VIEWPOINT ESTATES FILING NO. 2

A VACATION AND REPLAT OF LOTS 71 AND 72, VIEWPOINT ESTATES
 A PORTION OF SECTION 10, TOWNSHIP 14 SOUTH, RANGE 63 WEST,
 OF THE 6th PRINCIPAL MERIDIAN, EL PASO COUNTY, COLORADO

OWNER OF RECORD AT TIME OF PLATING: VIEWPOINT ESTATES, LLC. PO BOX 6797 COLORADO SPRINGS CO. 80934-6797 (719)-338-5223		FINAL PLAT VIEWPOINT ESTATES FILING NO. 2	
MVE, INC. ENGINEERS SURVEYORS 1903 Lelaney Street, Suite 900 Colorado Springs CO 80909 719-635-5736 www.mveco.com		MVE PROJECT: 61099 MVE DRAWING: PLAT-PS1 DATE: NOVEMBER 8, 2021 SHEET: SHEET 1 OF 2

**AS - PLATTED**

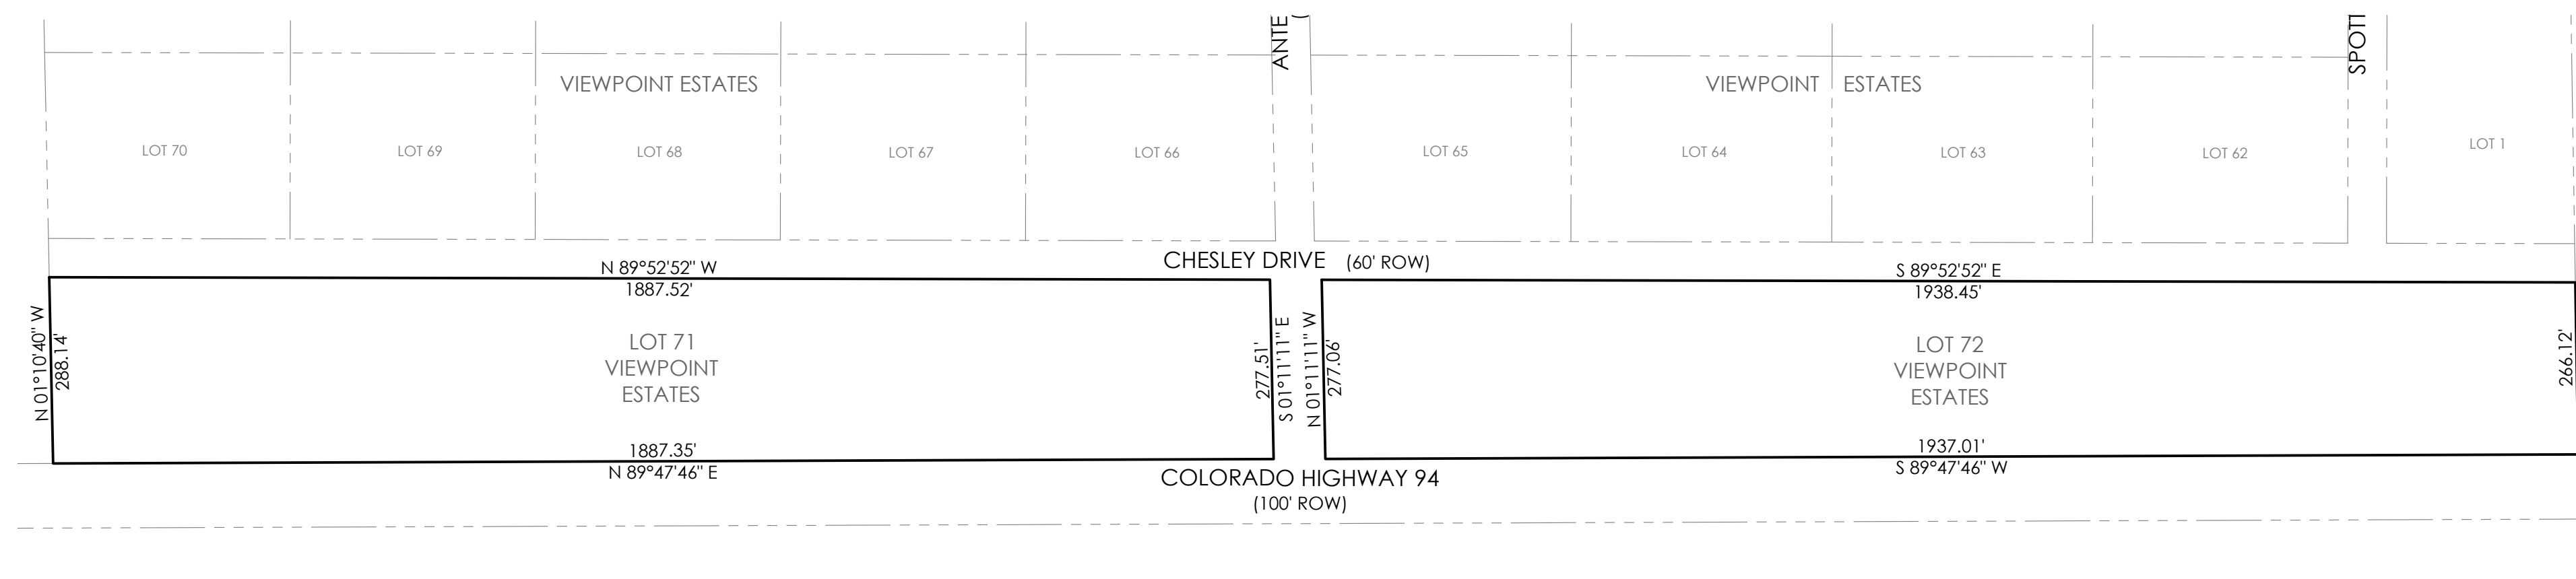
Add Water Resources Rpt, Traffic Study, Road Noise Study.

See note below for corrections required

AS-REPLATTED LOT 71, VIEWPOINT ESTATES

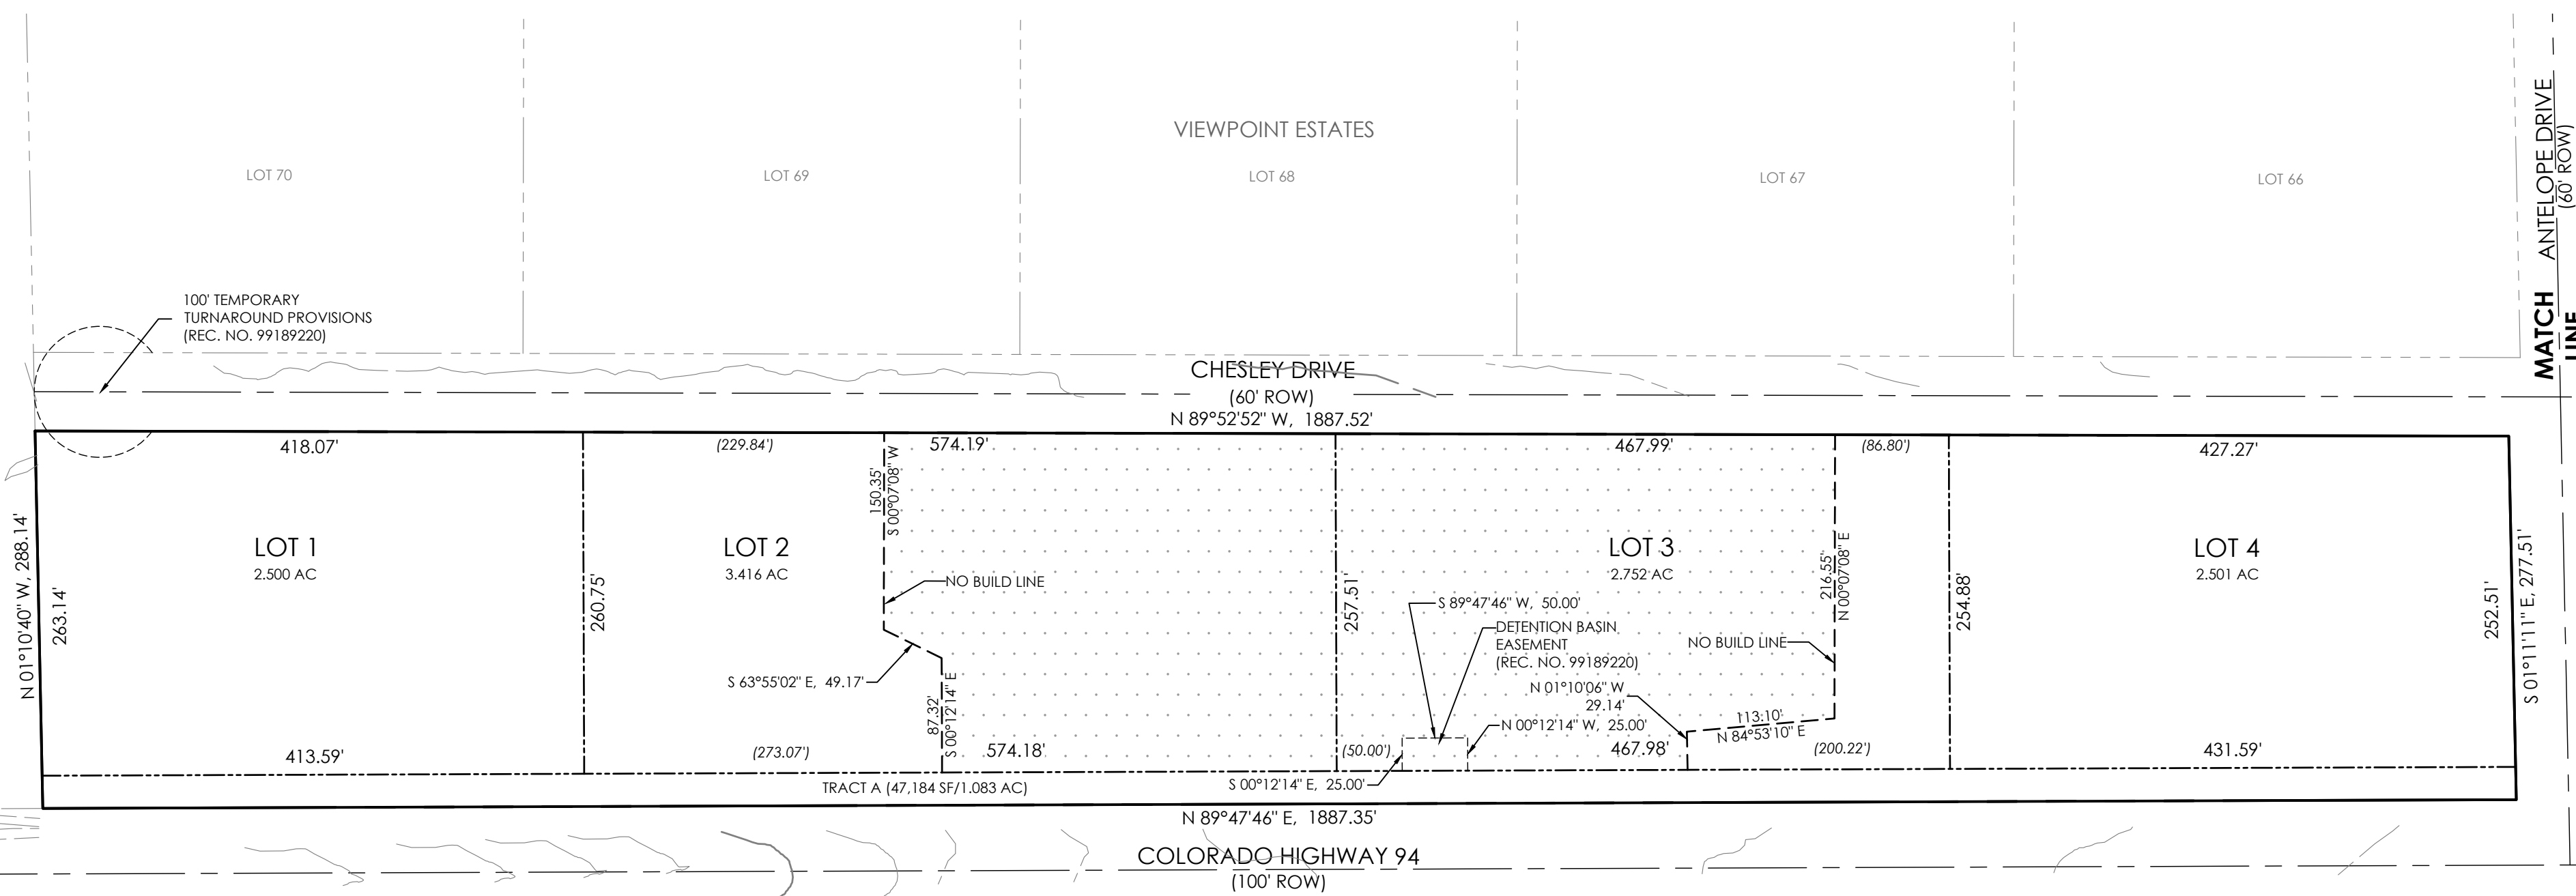
Note the detention basin easement shown on the SF98040 construction drawings is 50ftx50ft. Is basin smaller now? Or just the easement? Just confirm that the 25x50 easement is sufficient.

Add no build below elevation note

Label the bearing for all internal lot lines

Confirm that this is still a buildable lot

Include bearings on all internal lot lines and easements/no-build areas

AS-REPLATTED LOT 72, VIEWPOINT ESTATES

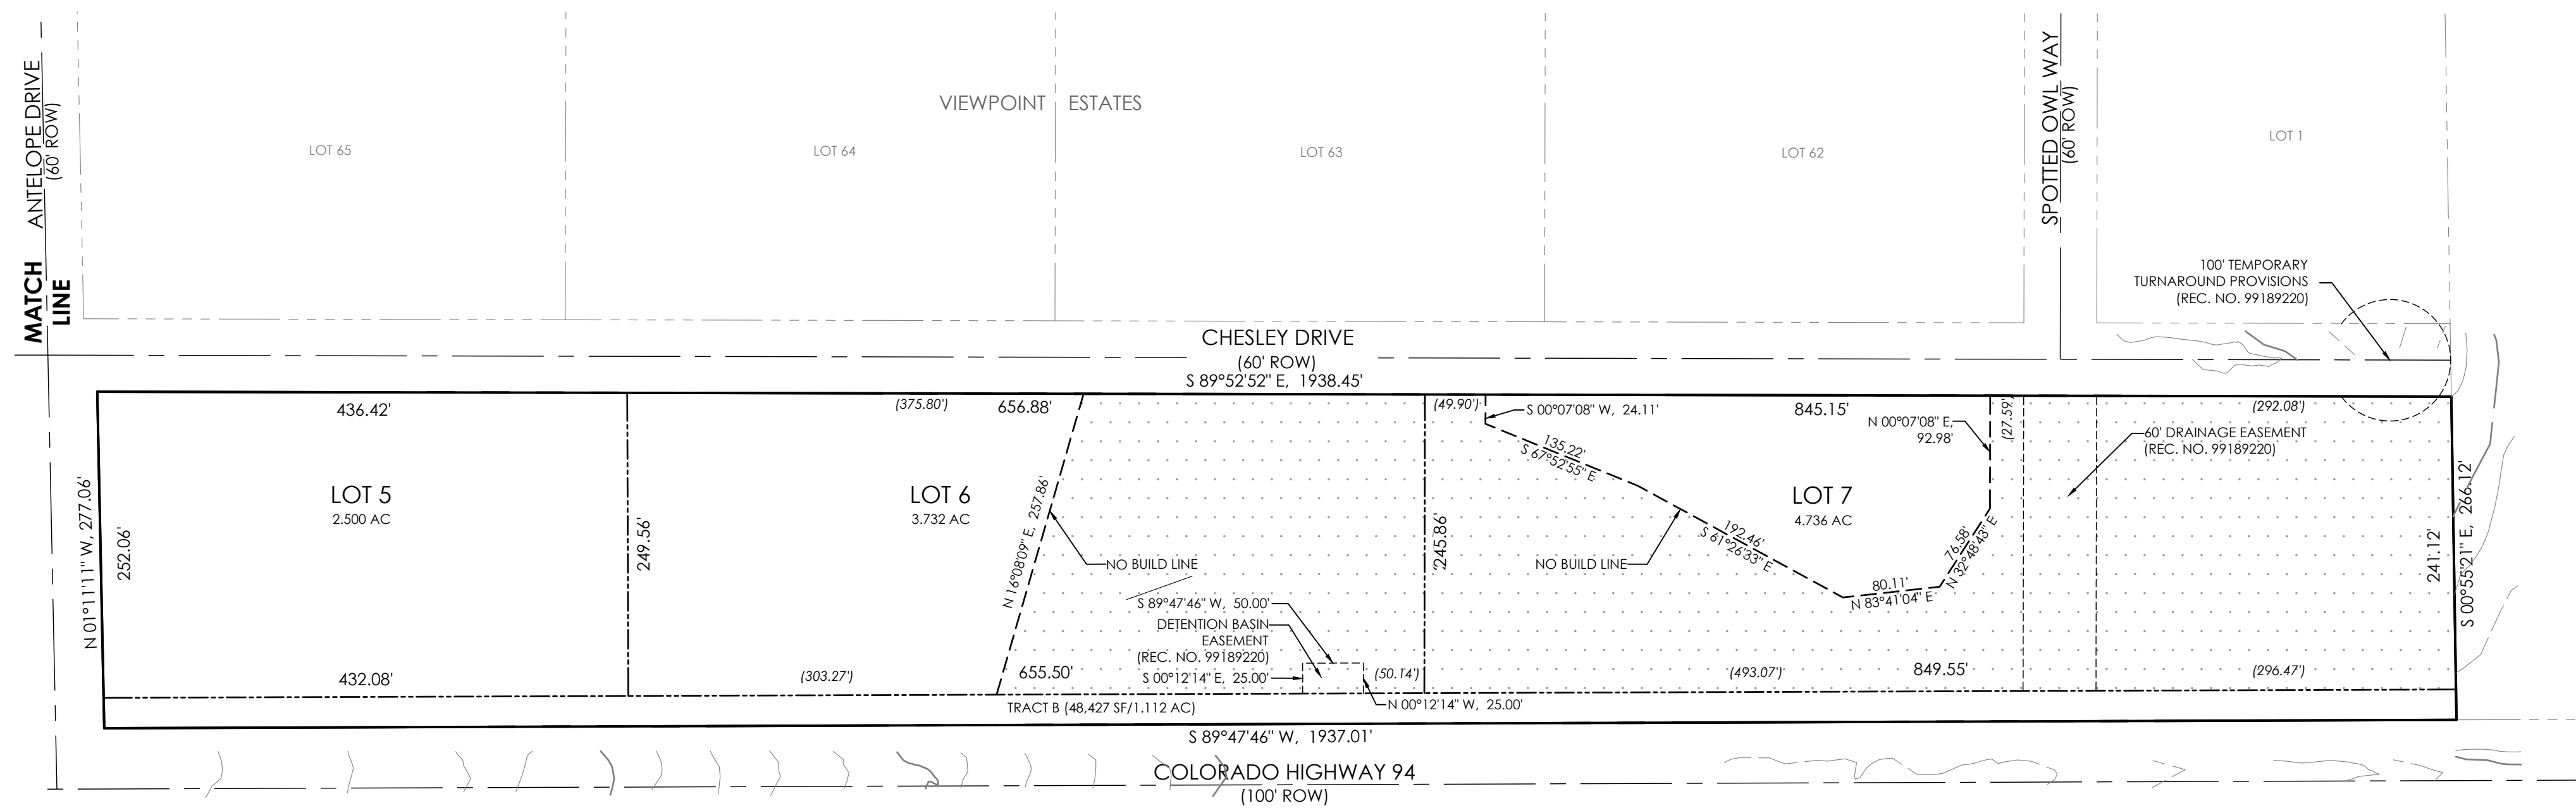
Add width of ROW dedication

Include roadway classification

AS-REPLATTED LOT 72, VIEWPOINT ESTATES
